New porch, rear extension and extend and alter roof to form a fourth bedroom, box room and shower.

44 Jubilee Avenue Rustington

Thank you for your internet representation made on 14th February 2013 which has been recorded as '**an objection**' with the comments as follows:

**To form
New Porch
Family Room
And 4th. Bedroom**

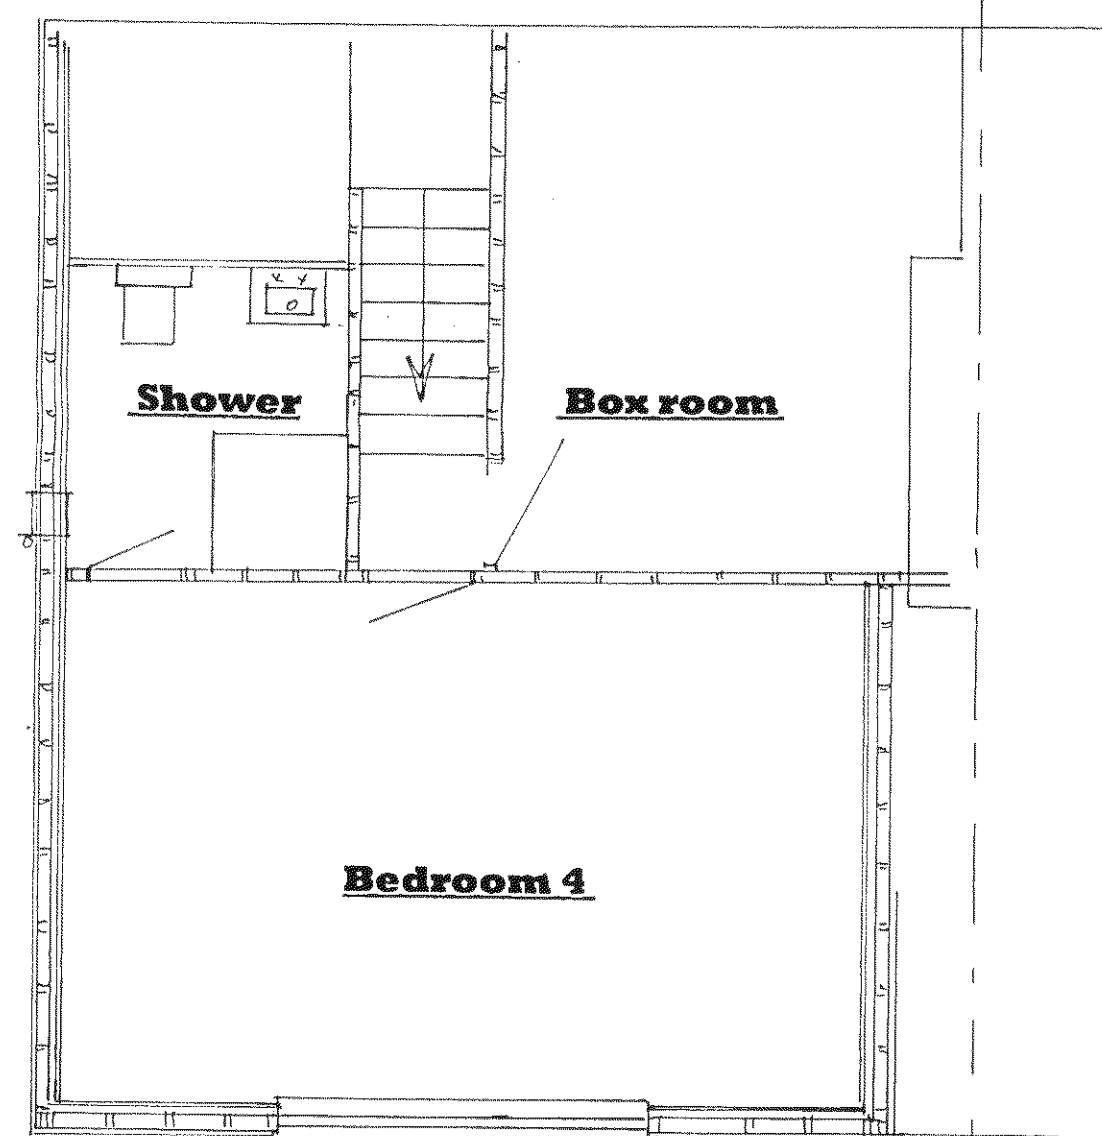
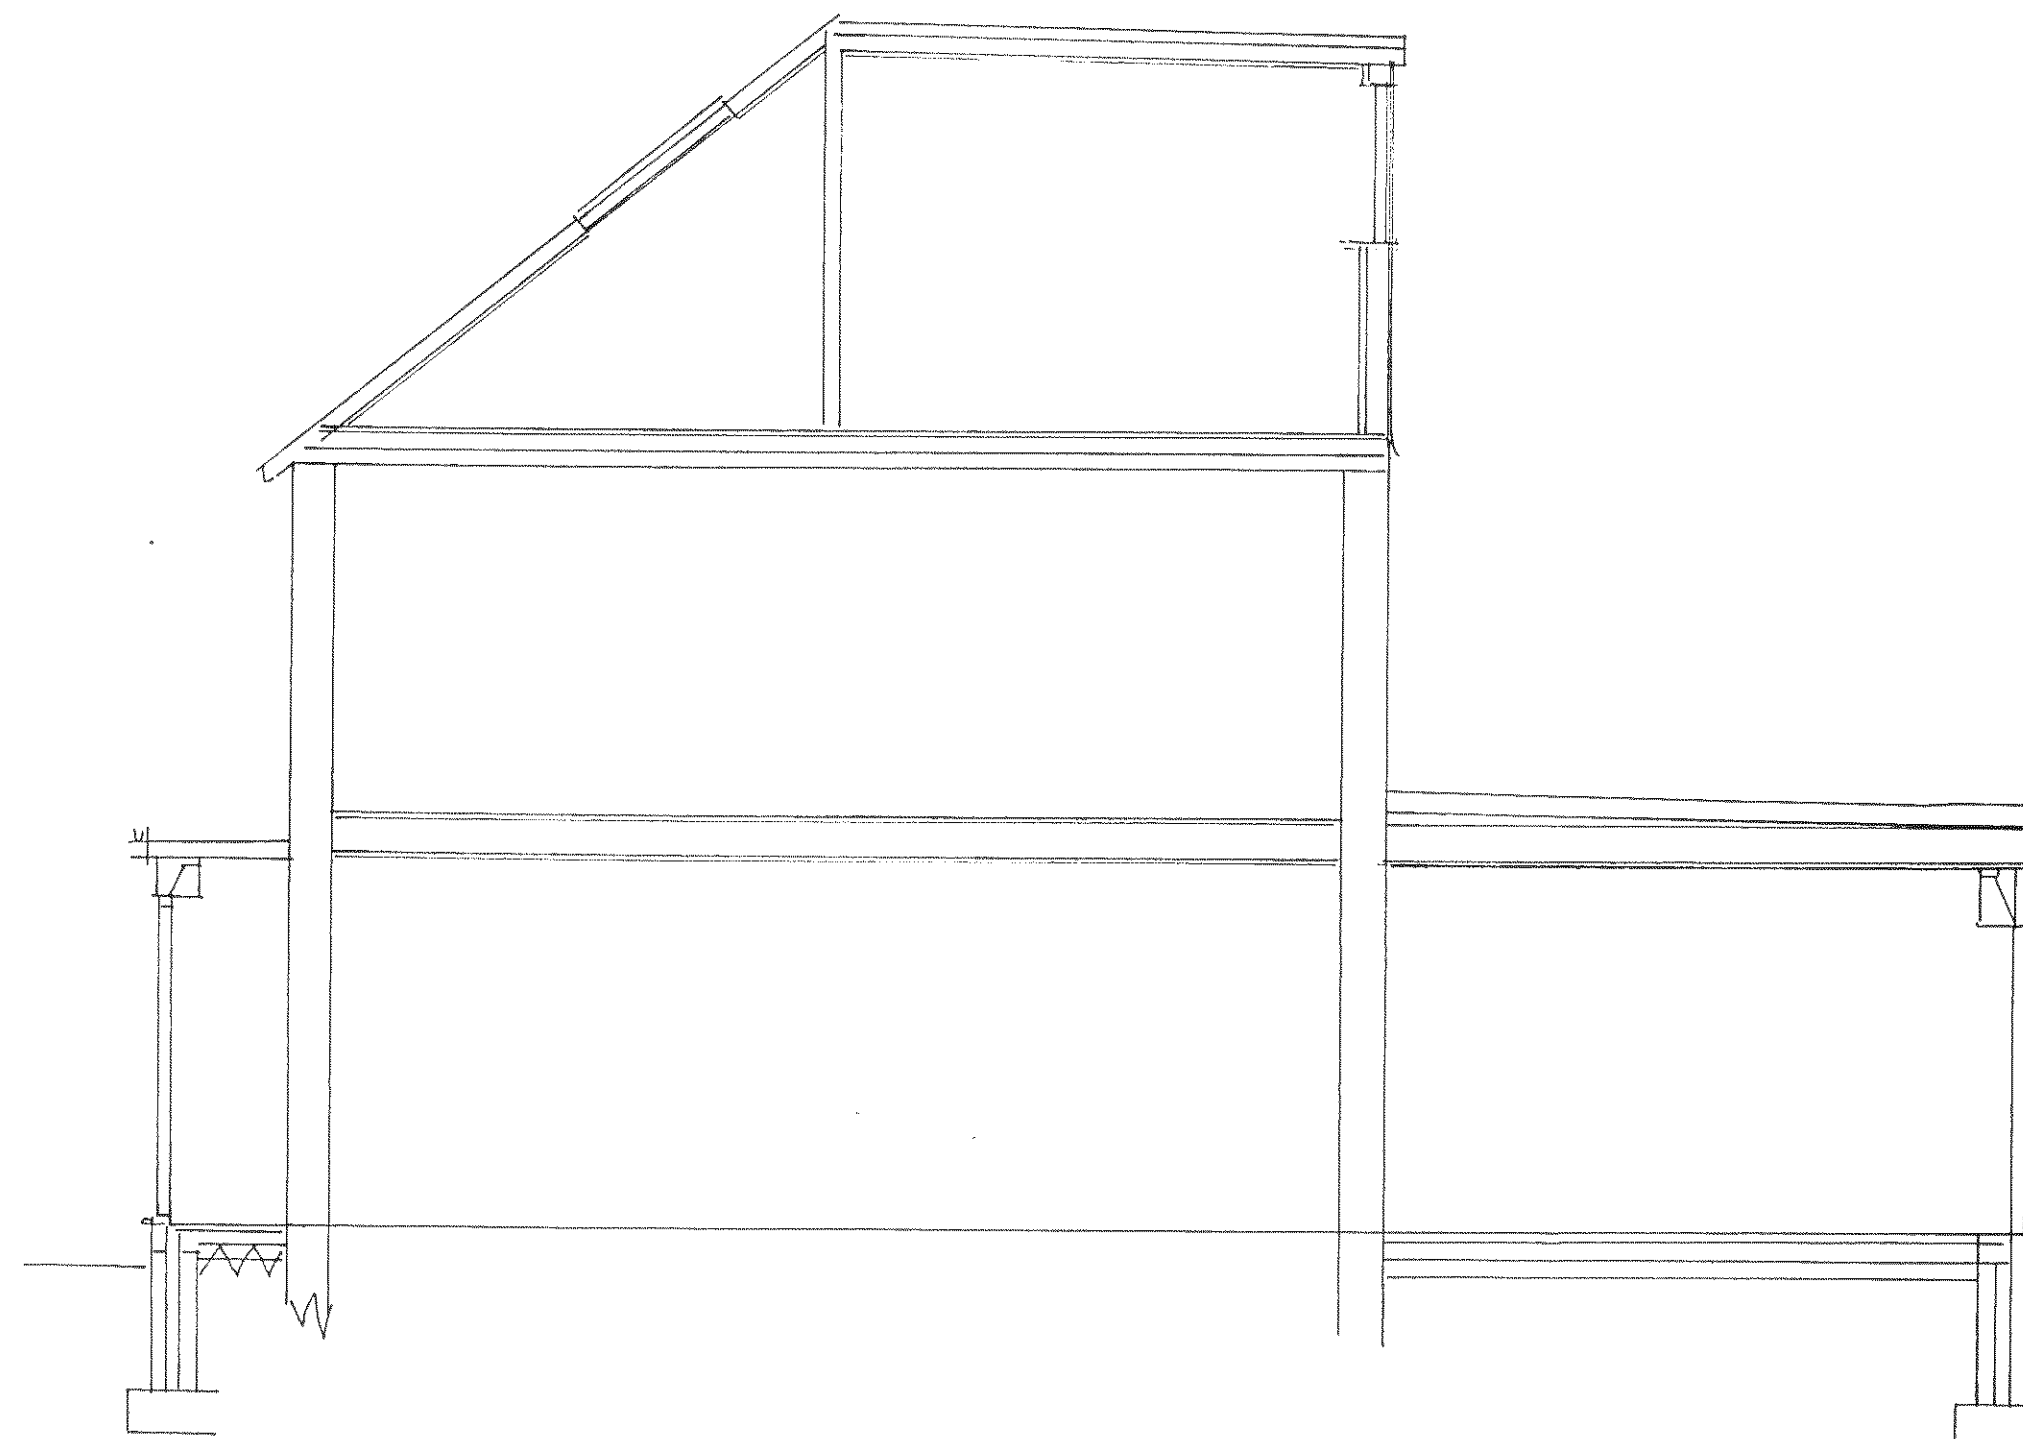
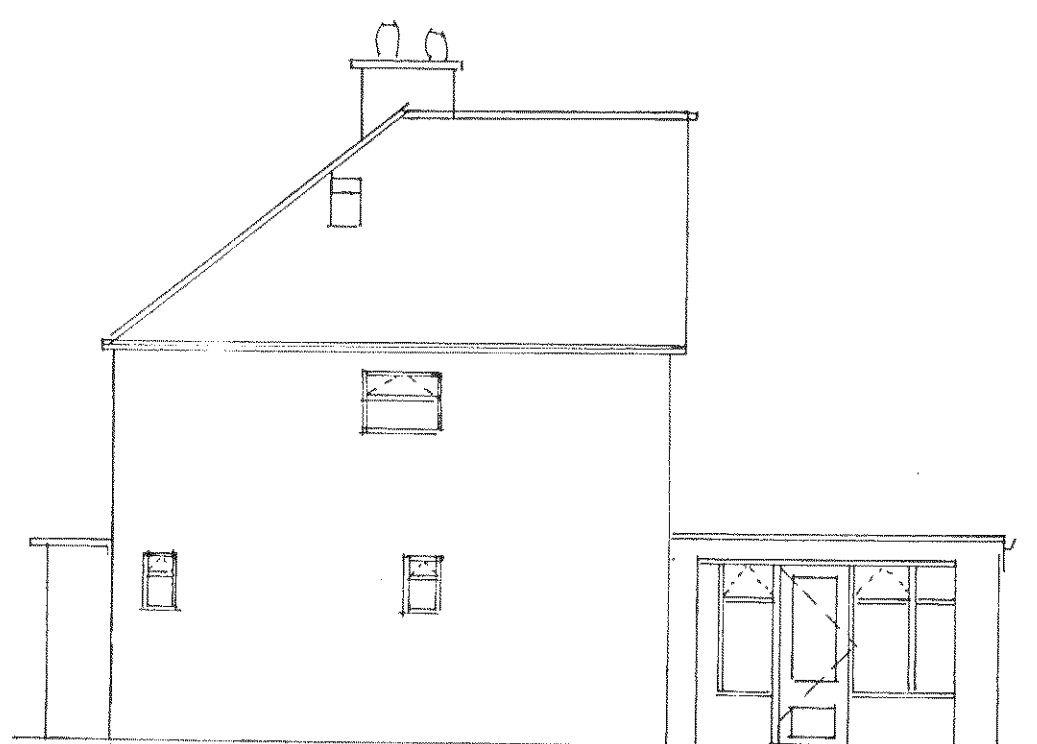
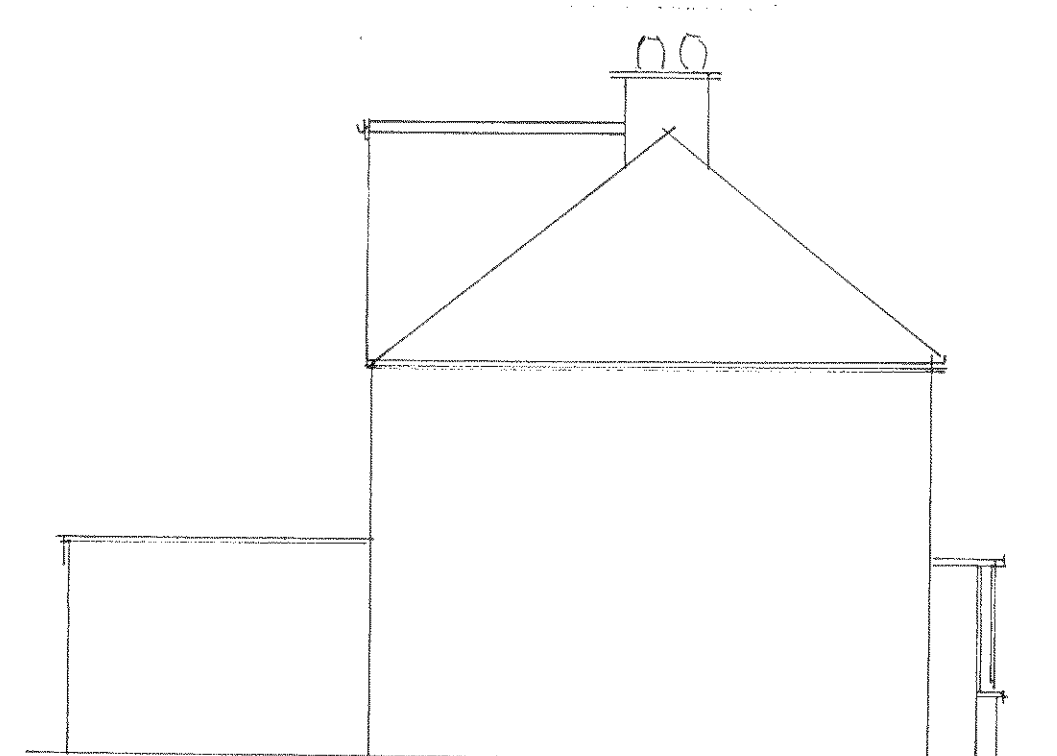
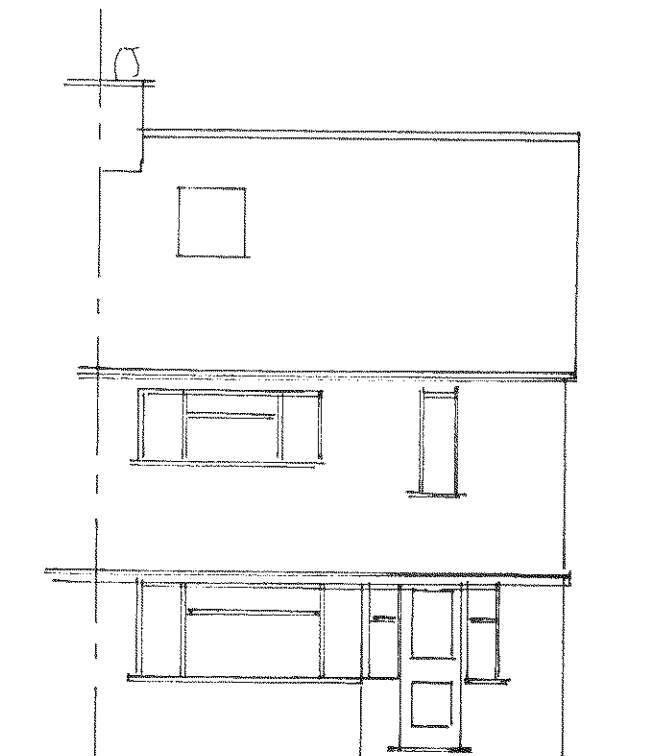
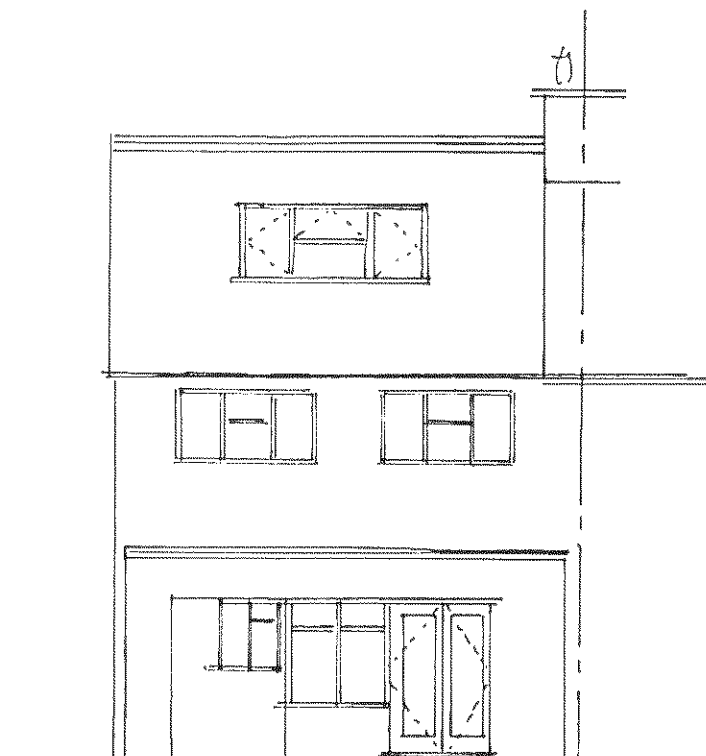
(i) The proposal, by reason of its height and mass, would present an over-bearing appearance which would result in a loss of light and privacy for the occupiers of No. 42 Jubilee Avenue. It would, therefore, have a detrimental effect on the visual amenities and quiet enjoyment of the occupiers of the aforementioned property, together with other neighbouring properties within close proximity of the site, and in particular, No. 46 Jubilee Avenue.
